ASSESSMENT REPORT

Cobaki Estate Residential Community Development Project Approval MP08_0200 (MOD 5)

This report is an assessment of a request to modify the Project Approval MP08_0200 for a residential community development, referred to as 'the Cobaki Estate' at Cobaki Lakes. The request has been lodged by Leda Manorstead Pty Ltd (the Proponent), pursuant to section 75W of the *Environmental Planning and Assessment Act 1979* (EP&A Act). It seeks approval to amend an approved fencing plan designed to protect environmentally sensitive areas of the site from bulk earthwork activities and to delete a condition relating to a raptor nesting site.

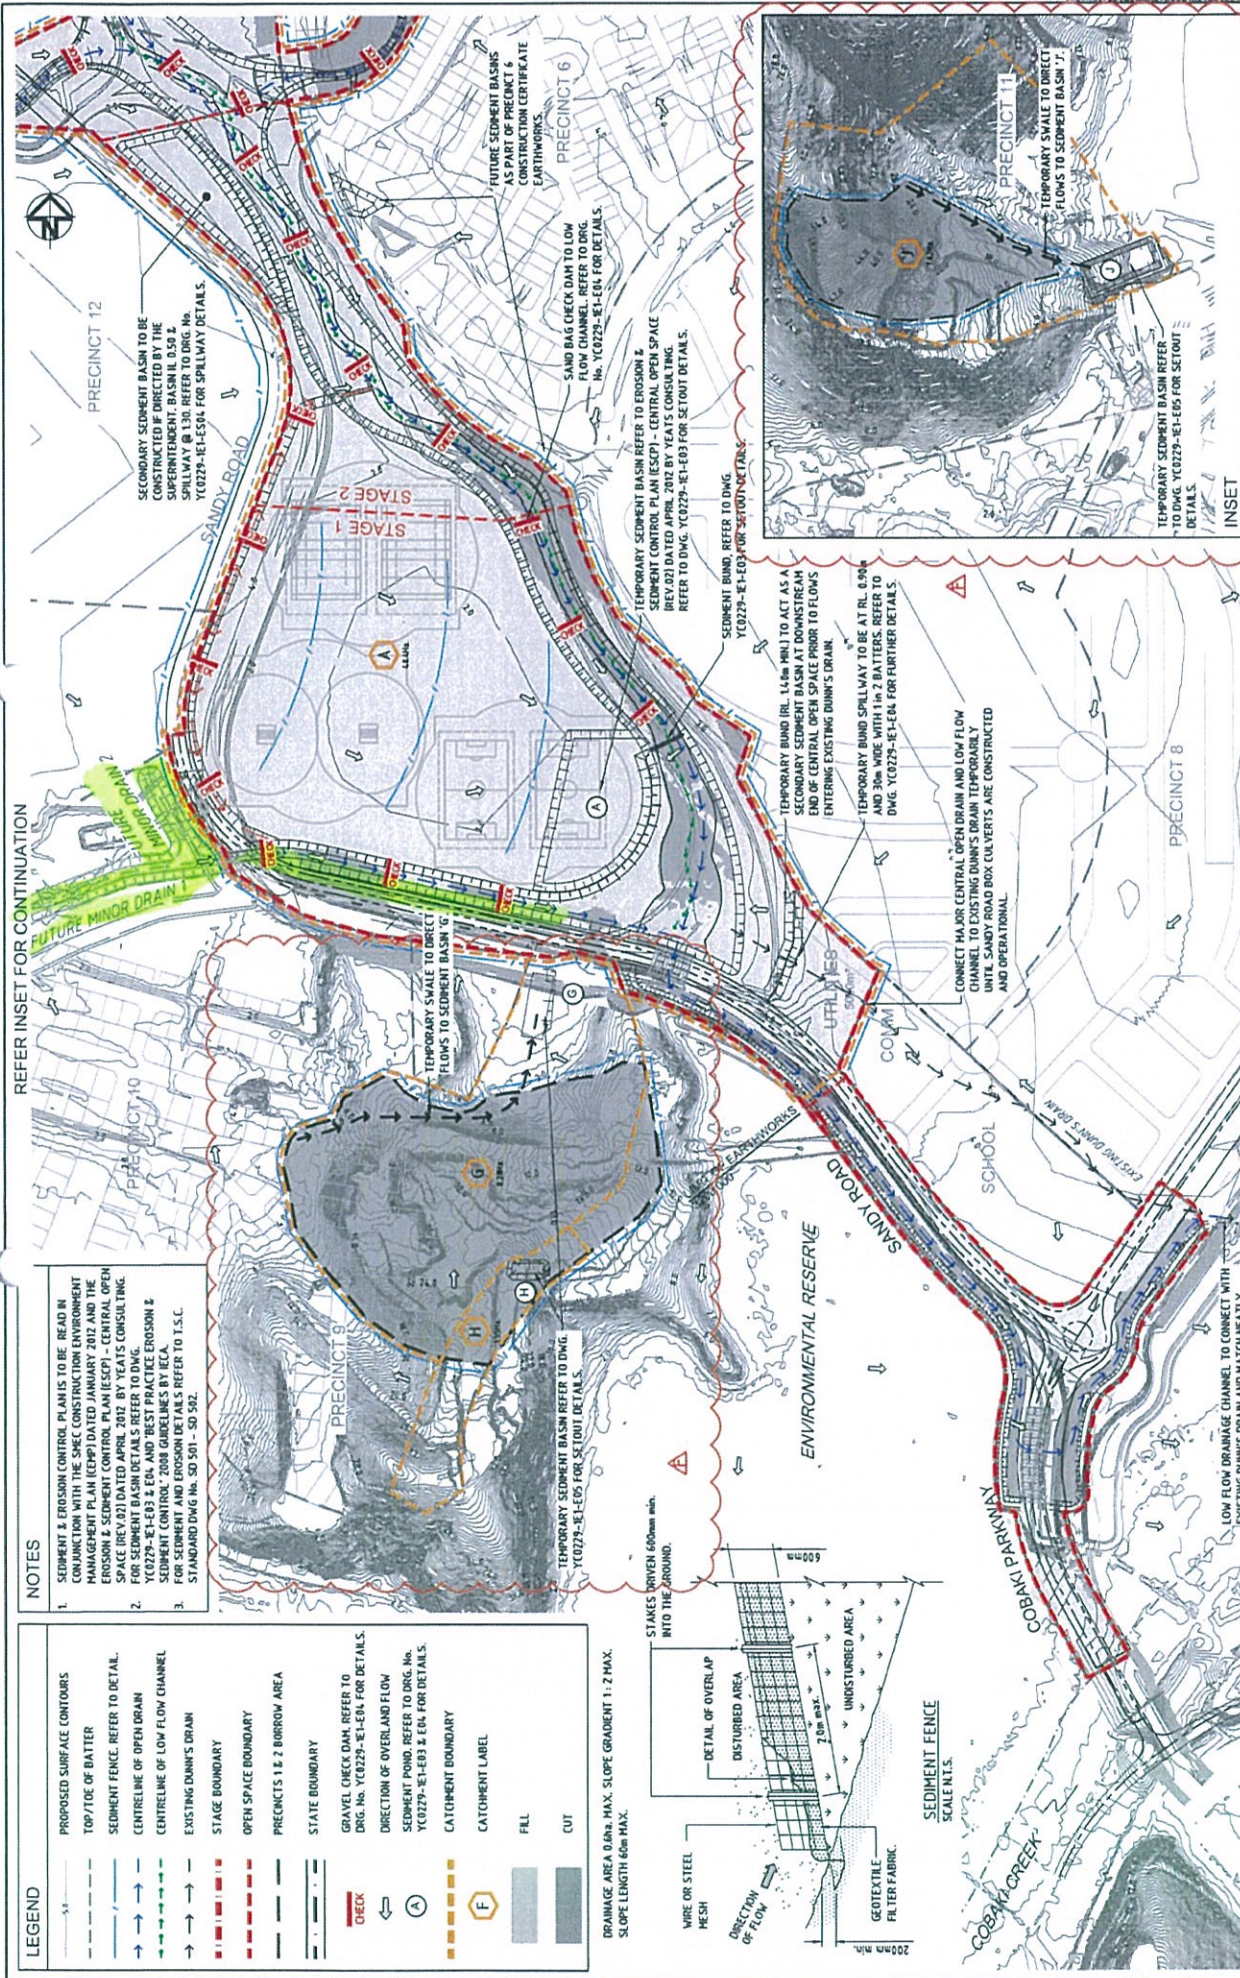
The Proponent lodged a section 75W modification request seeking to amend an approved earthworks fencing plan referred to in Condition 39(A) of the approval. Despite the fencing already being erected on the site (in accordance with the MOD 2 CEMP and the previously approved fencing plans) the Proponent has requested the plan be amended by removing fences from six specific areas of the site as shown in **Figure 7**. The revised fencing plan is shown in **Figure 8**.

The Proponent advises all of the fences have been erected on the site and there is no intention to remove them in the future. However, the Proponent seeks to delete the fences from the approved plan as it considers they are not necessary to protect the environmentally sensitive areas of the site. Further, the Proponent is concerned that if vandals trespass onto the site and damage the fences, it may be found to be non-compliant with the approval. The Proponent also considers the various versions of the fencing plan are only relevant to the works approved in each particular modification request. The Proponent is of the view that the fences shown on the plan submitted with MOD 2 were inadvertently carried over from previously approved plans and are not relevant to the specific works approved by MOD 2.

Raptors' Nesting Tree in Precinct 11	The approved fencing plan includes a 100 metre wide buffer around a raptors' nesting tree in Precinct 11, which as noted above has been felled since the modification was approved. Although the tree no longer exists, two Ospreys have made a new nest in a nearby tree. The fencing plan has therefore been updated to reflect a buffer around the new nesting tree.

The Department considers the approved fencing provides a practical mitigation measure to protect the environmentally sensitive areas of the site during the bulk earthwork activities across the site. To now amend the plan, allowing some fences to be removed would result in unacceptable risks to areas of the site identified for protection and/or rehabilitation, as it would:

- reduce the potential for natural regeneration of these environmentally sensitive areas.
- Specific consideration has also been given to each of the fences (Areas 1 to 6) sought to be deleted from the fencing plan (**Appendix A**). In summary, the Department considers fencing for each of the six areas should be maintained, given the sites' environmental sensitivity and close proximity to construction activities.

The Department's assessment therefore concludes the environmentally sensitive areas of the site should be protected by fencing to prevent potential disturbance from earthwork activities and to allow the areas to naturally regenerate. Consistent with OEH's position, the Department does not support amending the approved fencing plan.

The Department's assessment therefore concludes the fences shown on the fencing plan, approved as a part of MOD 2, accurately reflect the fencing required to protect the environmentally sensitive areas of the site from the approved construction activities.

The Department has assessed the modification request and supporting information in accordance with the relevant requirements in the EP&A Act. The Department does not support the proposed amendments to the earthworks fencing plan on the basis it would:

Consequently, it is recommended the modification request be disapproved.
